PCD PROJECT NO. PPR-1950

ARACO CONCRETE
7470 SOUTHMOOR DR., COLORADO SPRINGS, COLORADO 80817

SITE GRADING & EROSION CONTROL PLAN

SITE GRADING & EROSION CONTROL PLAN

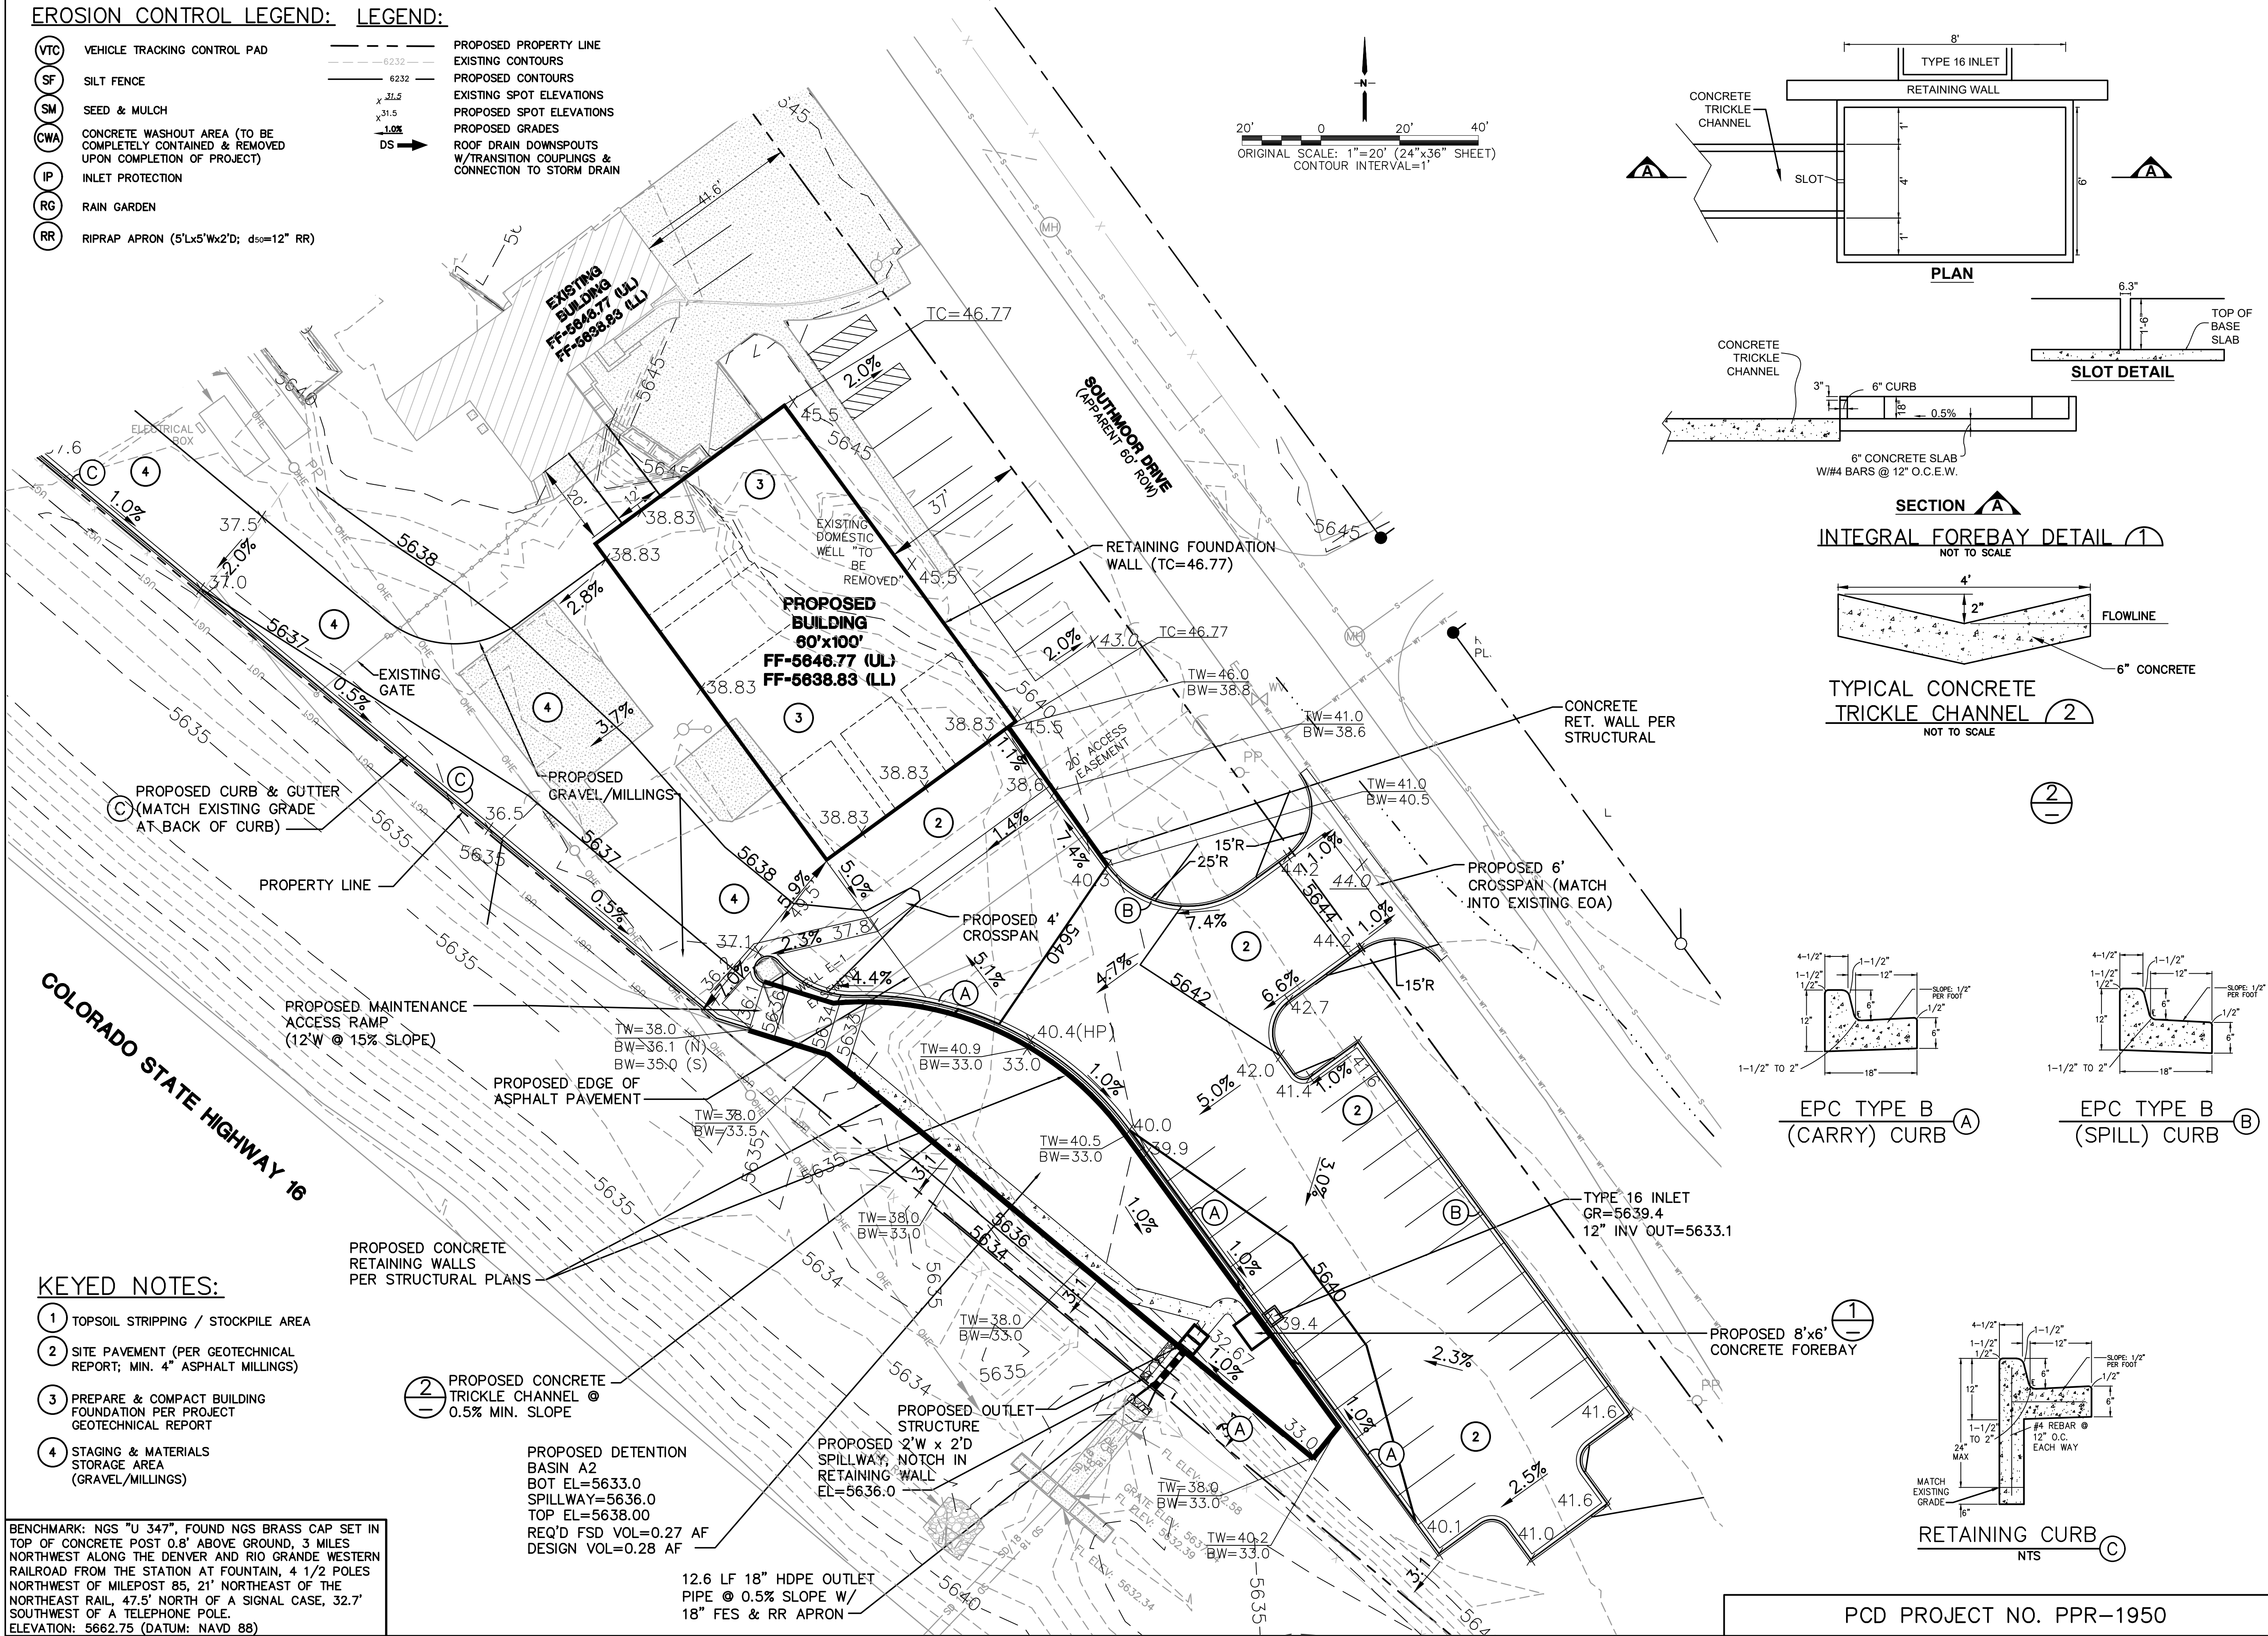
Please revise the concrete driveway and flared sections so that it does not extend into the existing asphalt/roadway. This comment was also provided on the site development plan

Please show the asphalt curb per comment on the site development plan
